**Subject:** AB/19/21/HH

**32 Maltravers Street Arundel BN18 9BU**

*Erection and replacement, with new, of an original chimney, the existing rear single storey extension, the external steel staircase and bridge, French windows, and new brickwork to the existing Twitten window, plus roof light, roof tiles and dormer lead cladding to the rear main roof.*

historical street view of the Parade with No32 in prominent position with front chimney in place

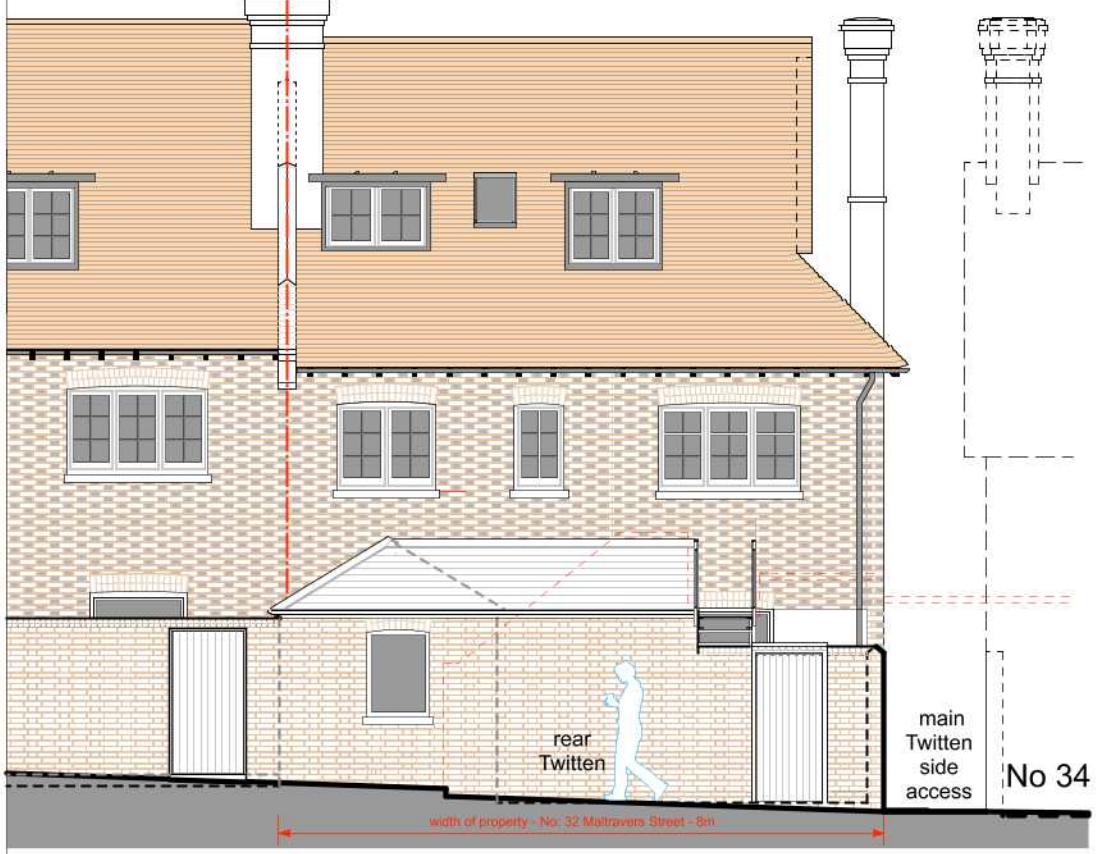
The erection of a new chimney to reflect one previously removed on the west elevation of the building is considered to be positive as it will re-introduce a lost element of the original design. I note that the intention is to replicate the previous chimney based on the photograph identified and included as part of the application. Whilst this is positive, I am of the opinion that it would have to

be carried out to a very high level of quality and detail so as to ensure that it has the desired impact. This will include high quality materials, mortar, pointing, appropriate brick bond etc. If minded to approve the application it is suggested that a sample of the brick should be agreed by the LPA along with the profile, dimensions and brickwork detailing (bond etc) of the chimney.

project: 32 Maltravers Street - Arundel - BN18 9BU			
drawing title: Existing & Proposed Ground Floor Plans			
drawing status: Planning Application Proposals			
date: 01 - 03 - 2021	scale at A3 original size 1:100	no: JW2012ARU - PL04	rev: E

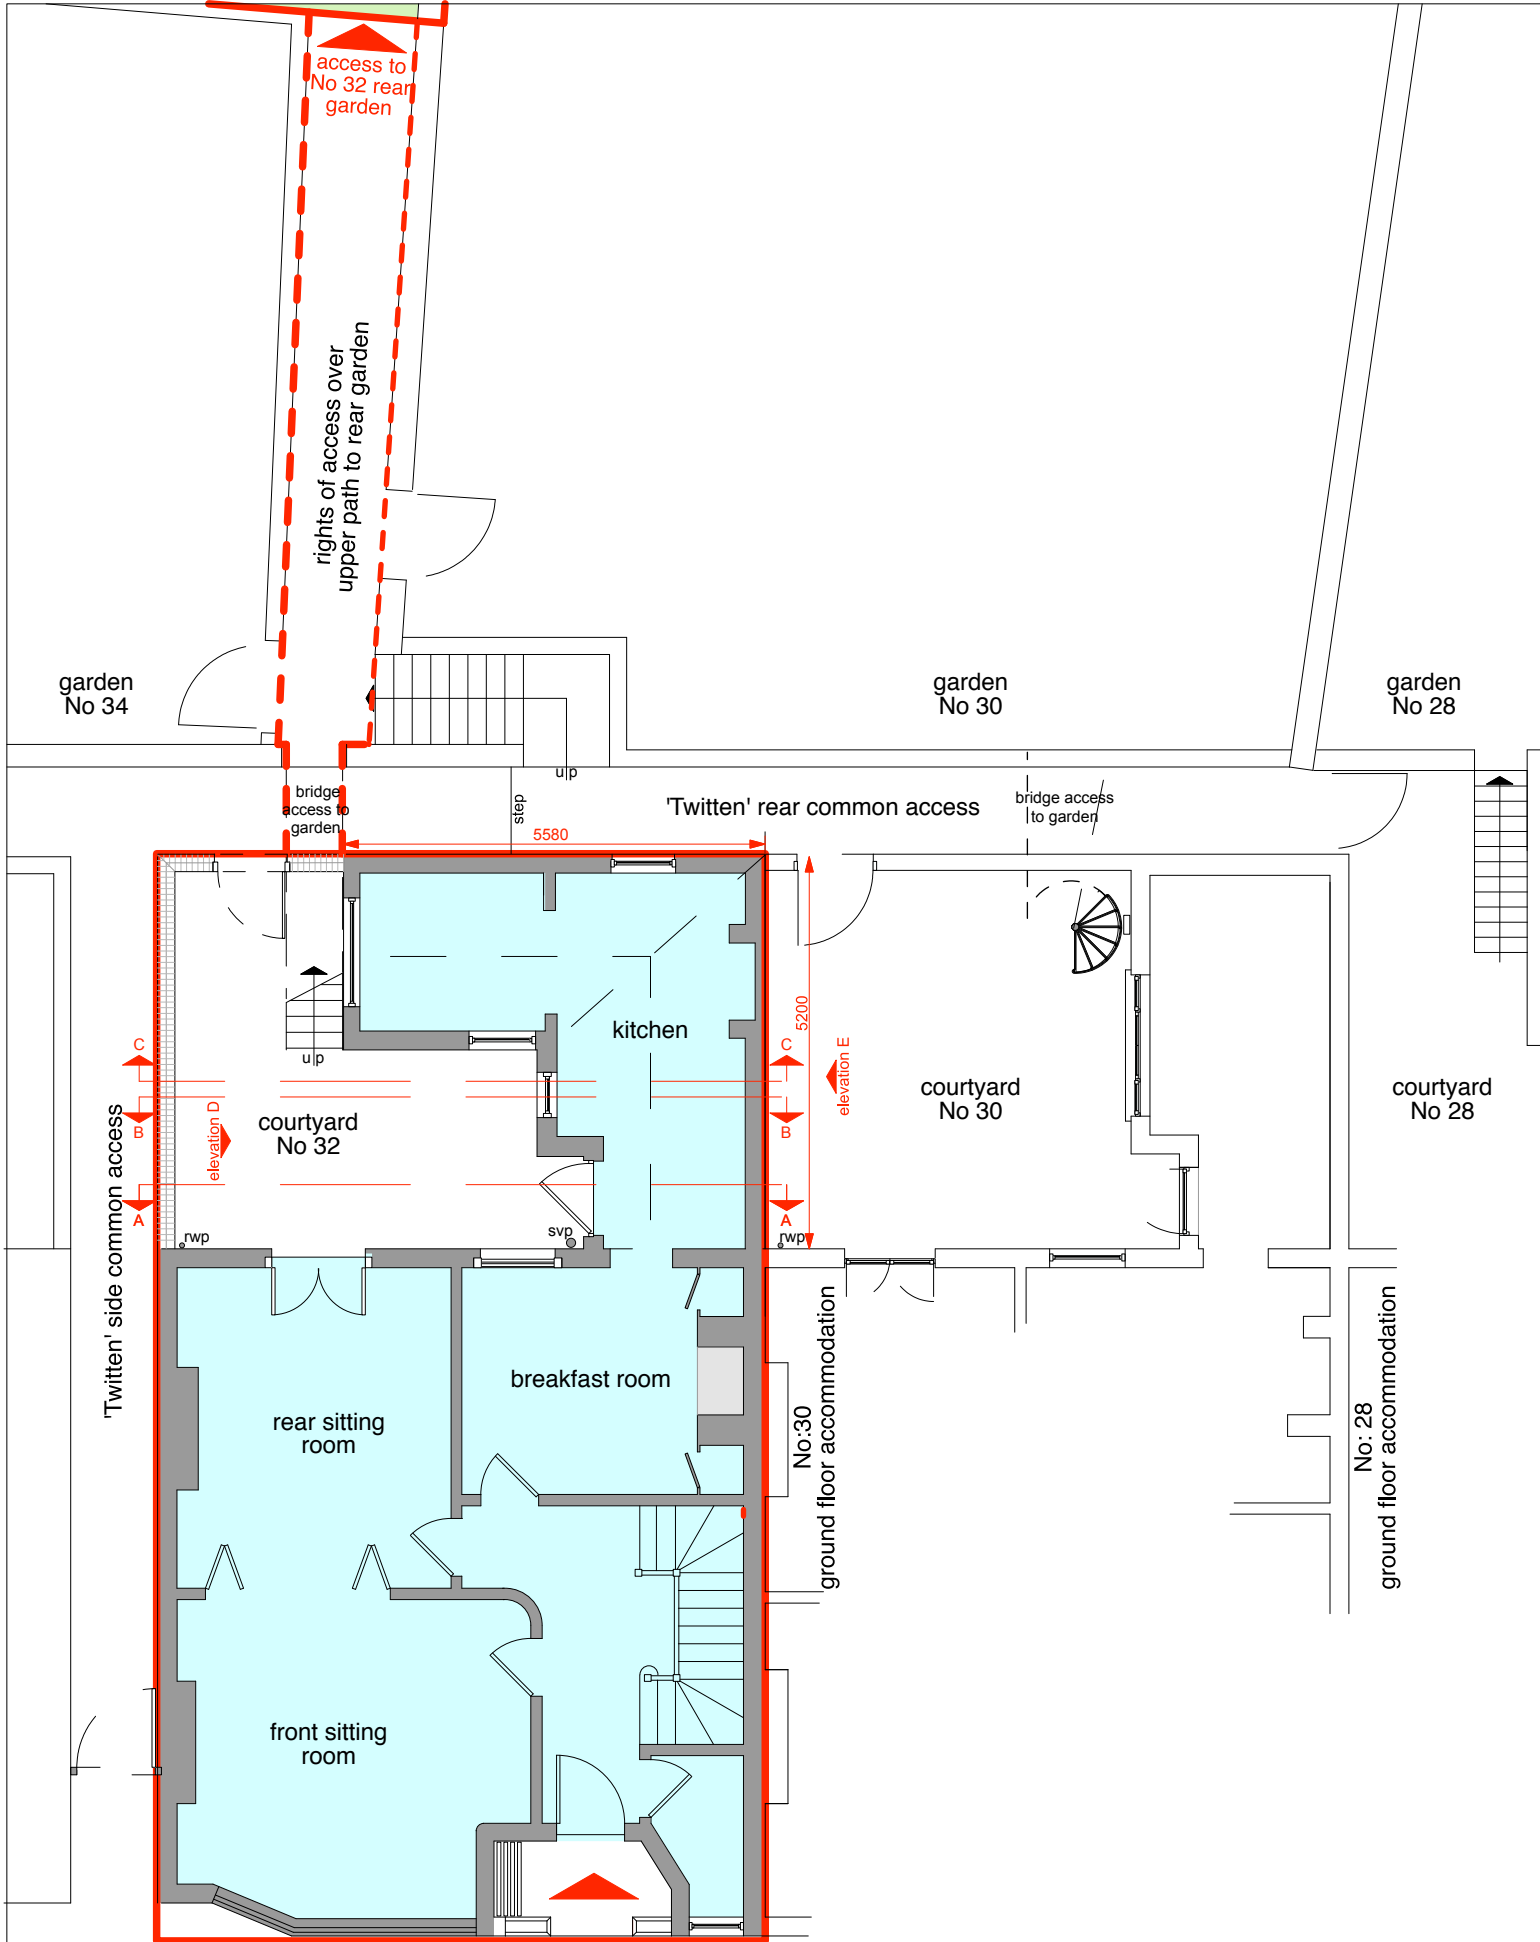
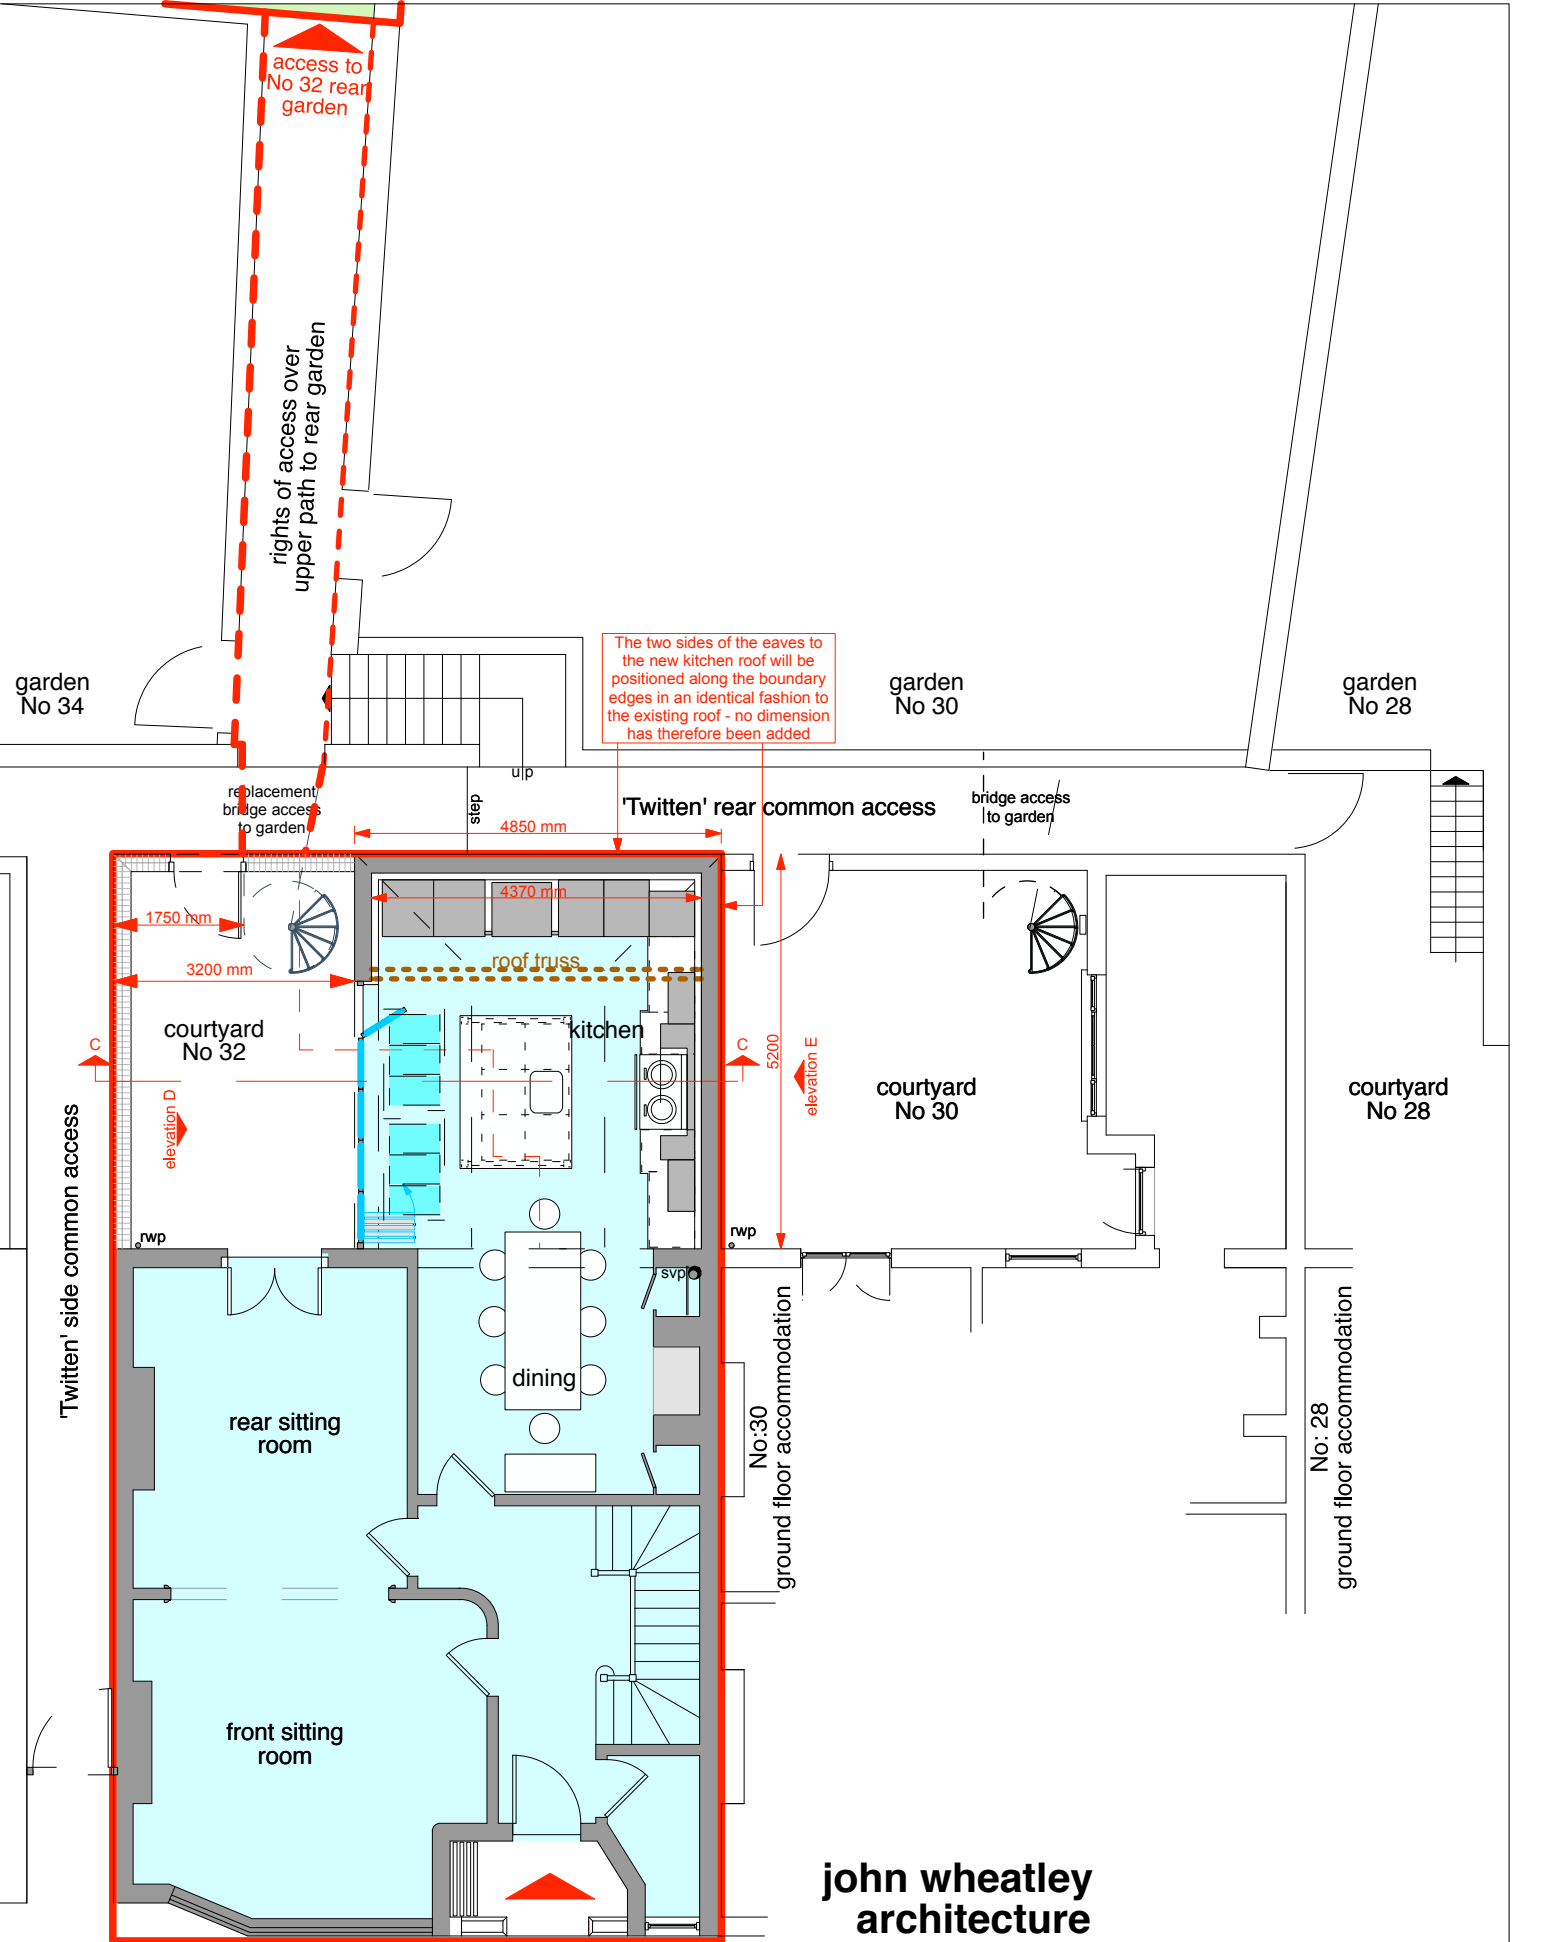
The alterations to the rear single storey element of the building will alter what appears to be the original layout of this part of the building. This will also remove a certain amount of historic fabric. However, it is also noted that it will allow the existing rooms to be better used, whilst also creating a more usable area of open space in the neighbouring courtyard. The proposed design is considered to reflect the host building, with a great deal of thought put into the appearance and materials. Likewise, whilst it would have helped to understand what the replacement French windows will look like, the reintroduction of ones of a more appropriate design will have a positive impact upon the building.

project:	32 Maltravers Street - Arundel - BN18 9BU		
drawing title:	Existing and Proposed Site & Roof Plans		
drawing status:	Planning Application Proposals		
date:	18 - 02 - 2021	scale at A3 original size	1: 200
no:	JW2012ARU - PL03	rev:	B

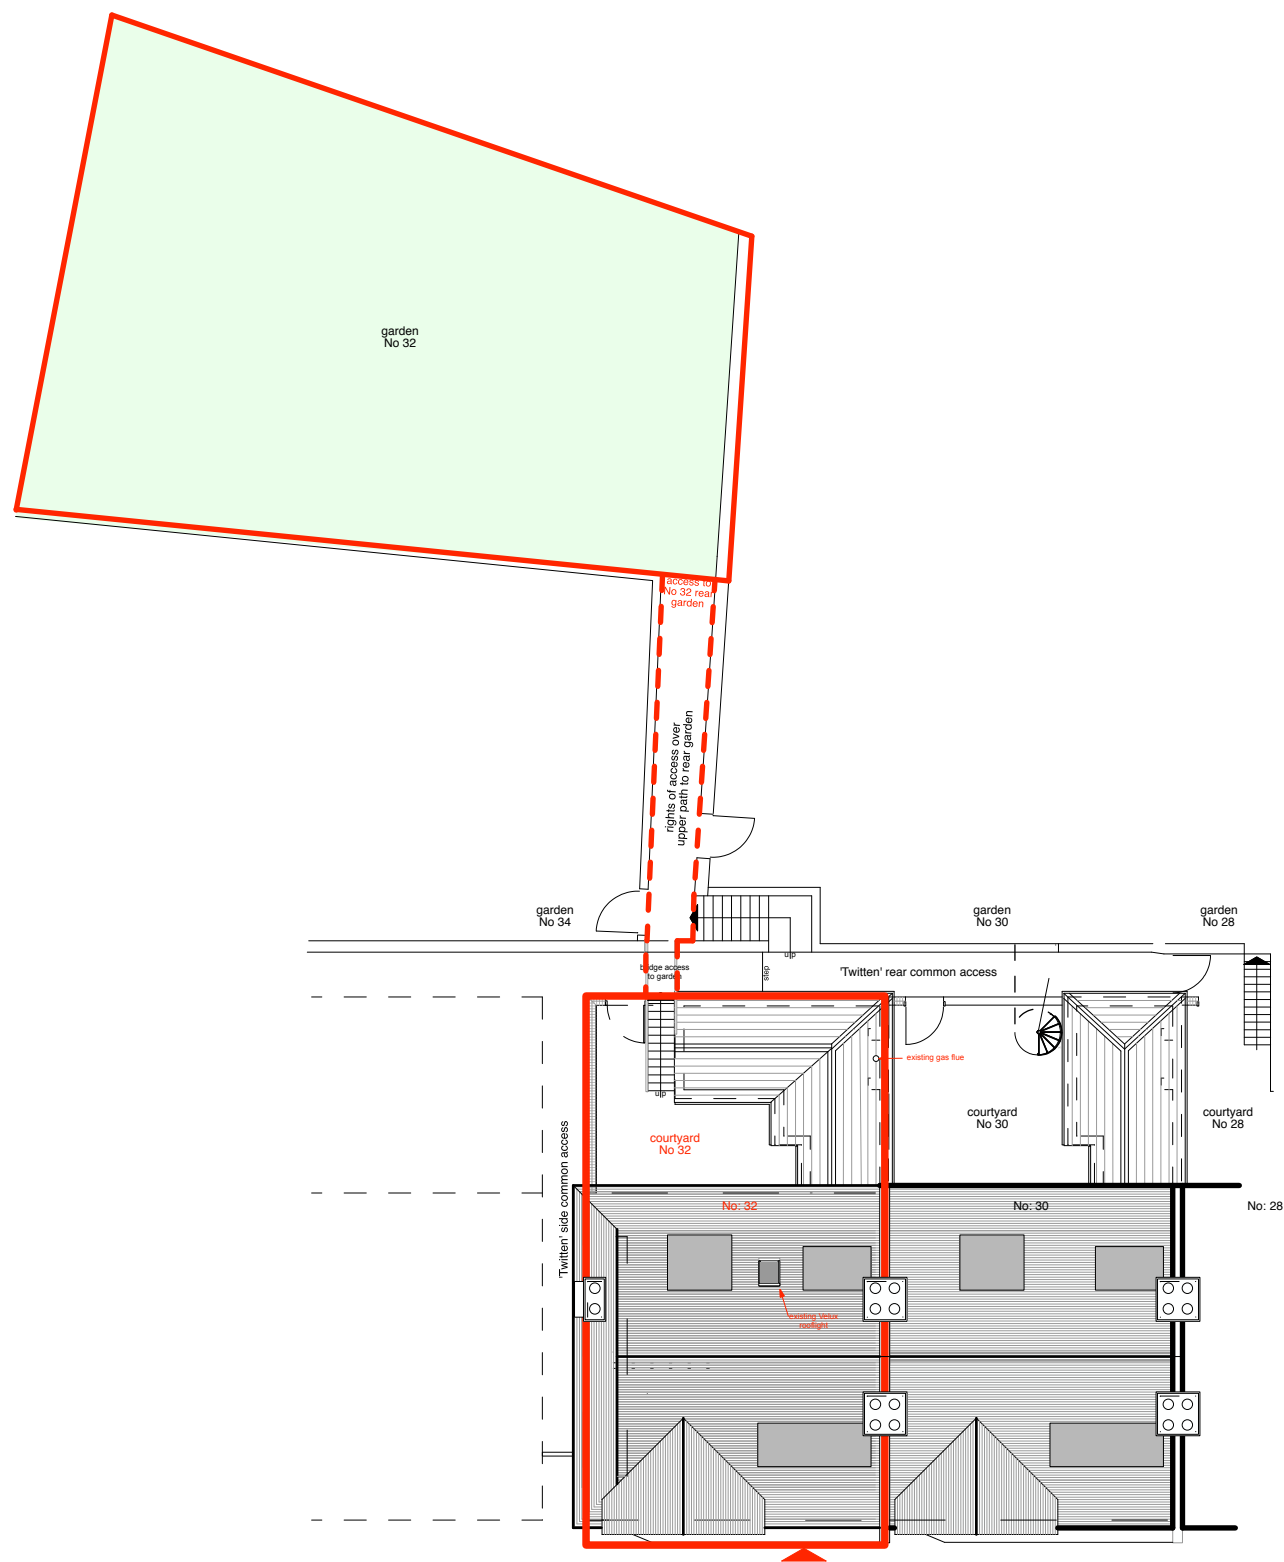
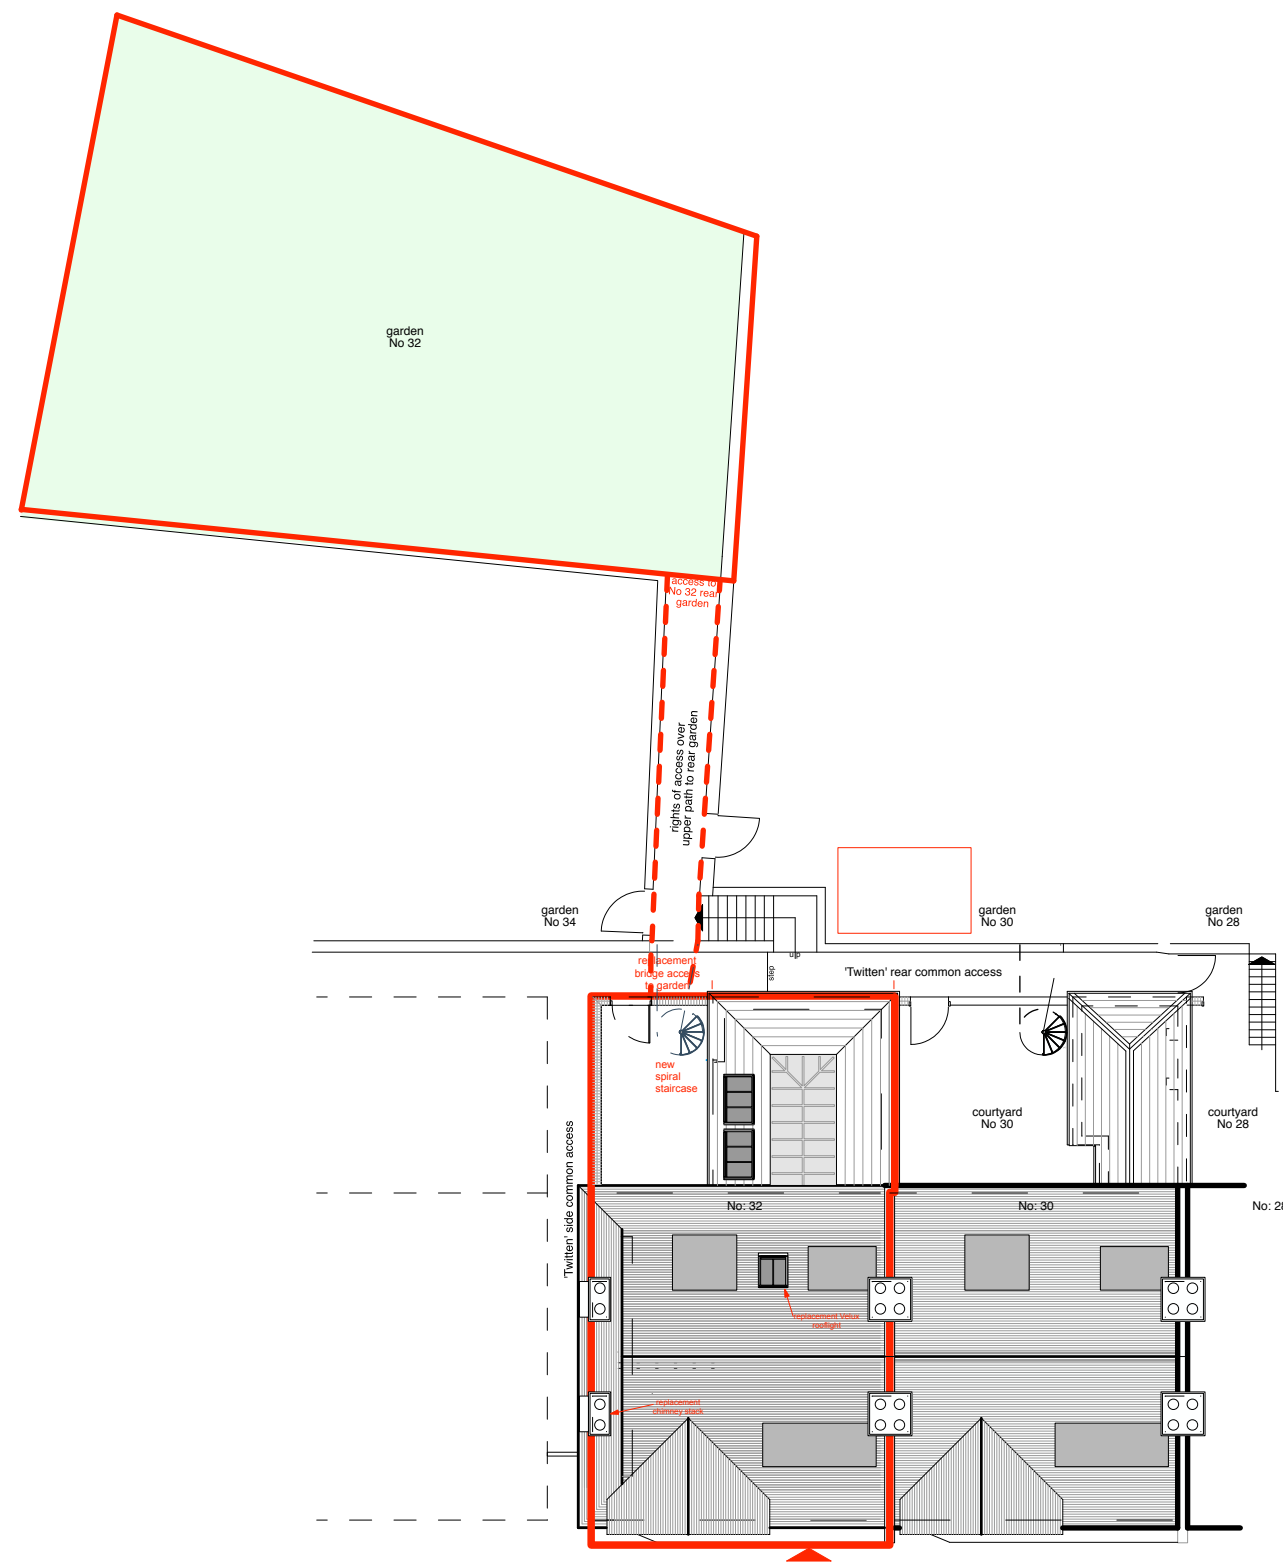
Both the replacement of the roof tiles and roof light on the rear elevation appear to be acceptable, as long as the replacement tiles are appropriate for the building.
